From: Plant, Tom - Communities <Tom.Plant@Oxfordshire.gov.uk>
Sent: 05 September 2019 11:58
To: Bob Neville
Cc: DC Support; Councillor Kieron Mallon
Subject: 19-01056-F - Barn And Land South West Of Cotefield Farm Church Street Bodicote

Planning application: 19/01056/F
Location: Barn And Land South West Of Cotefield Farm Church Street Bodicote
Description: Erection of garage adjacent to approved dwelling and change of use of land to residential
Type: Full Development
Case Officer: Bob Neville

Proposed West Elevation

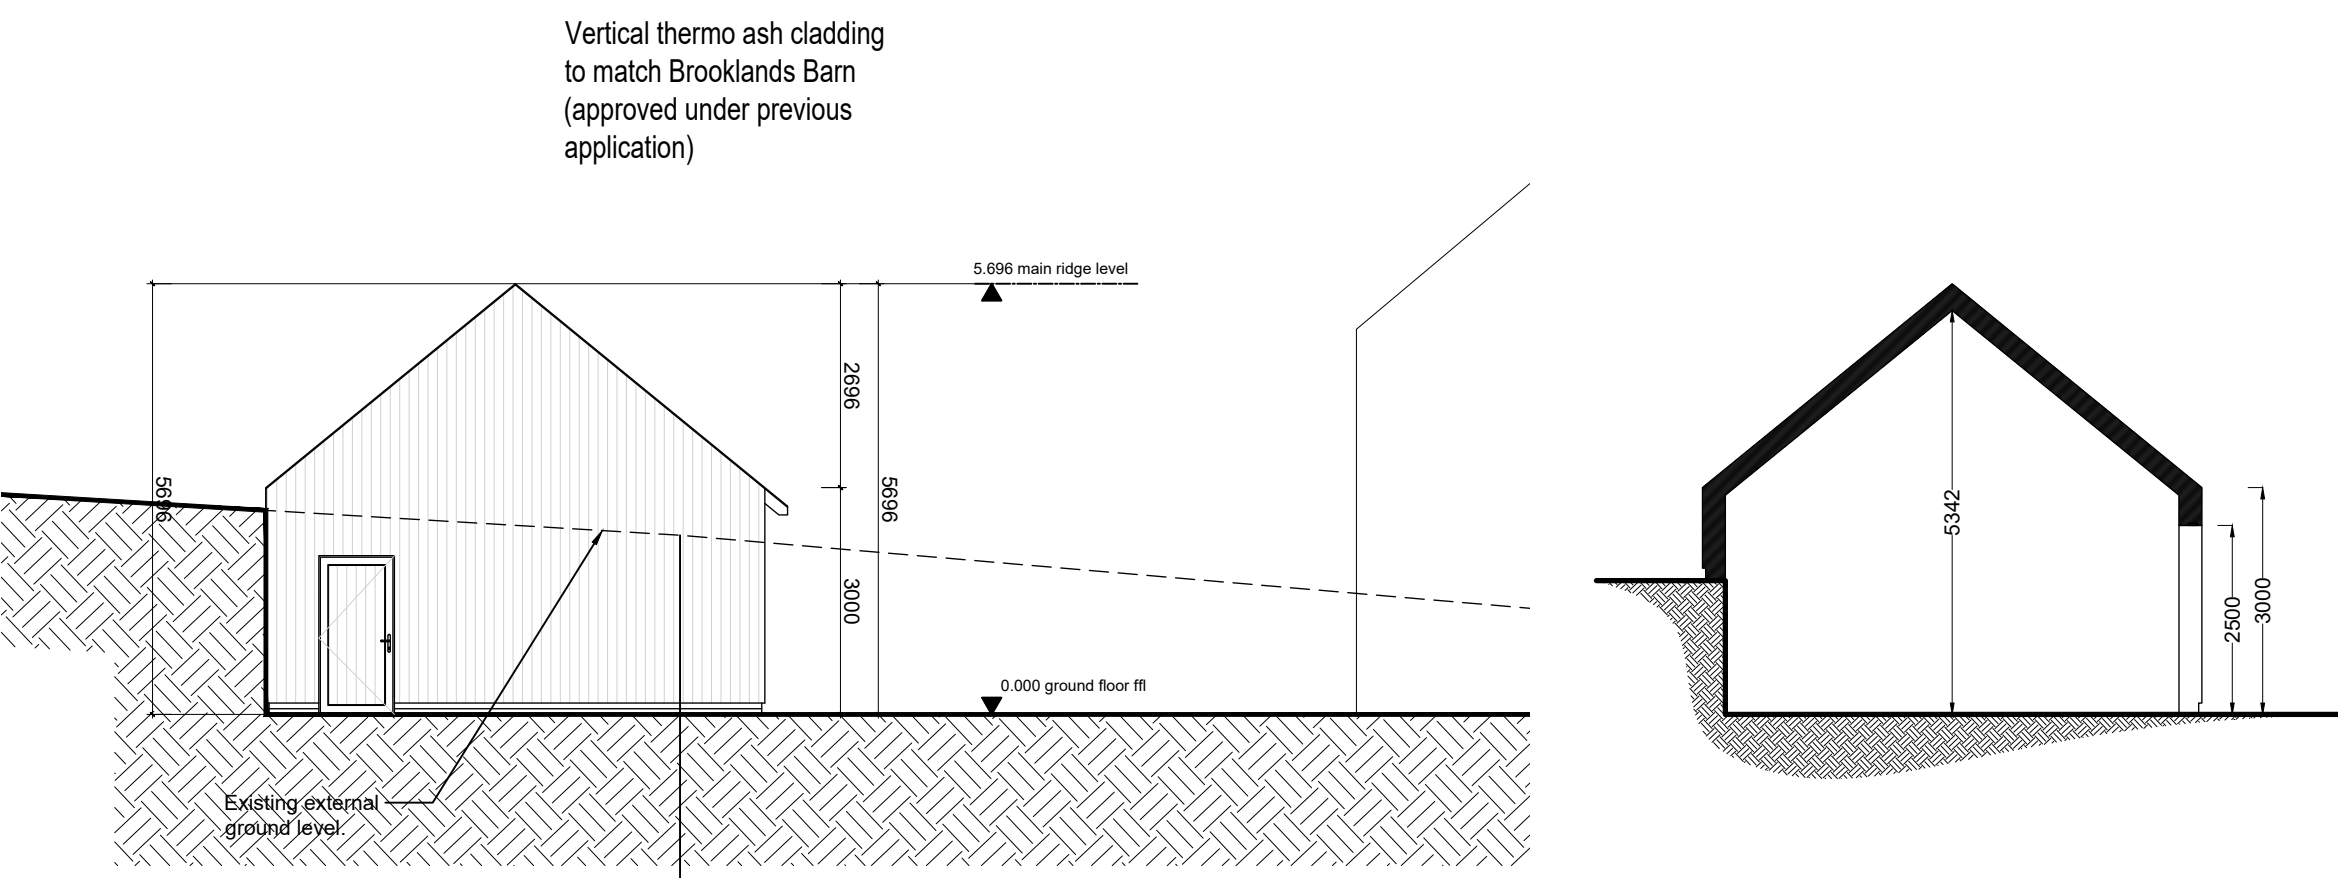
Prior to the first use/occupation of the development hereby approved, the parking and manoeuvring areas shall be provided in accordance with the plan approved (Drawing No. 4728/21D) and shall be constructed from porous materials or provision shall be made to direct run-off water from the hard surface to a permeable or porous area or surface within the curtilage of the site. Thereafter, the parking and manoeuvring areas shall be retained in accordance with this condition and shall be unobstructed except for the parking and manoeuvring of vehicles at all times. Reason - In the interests of highway safety and flood prevention and to comply with Policies ESD7 and ESD15 of the Cherwell Local Plan 2011-2031 Part 1 and Government guidance contained within the National Planning Policy Framework.
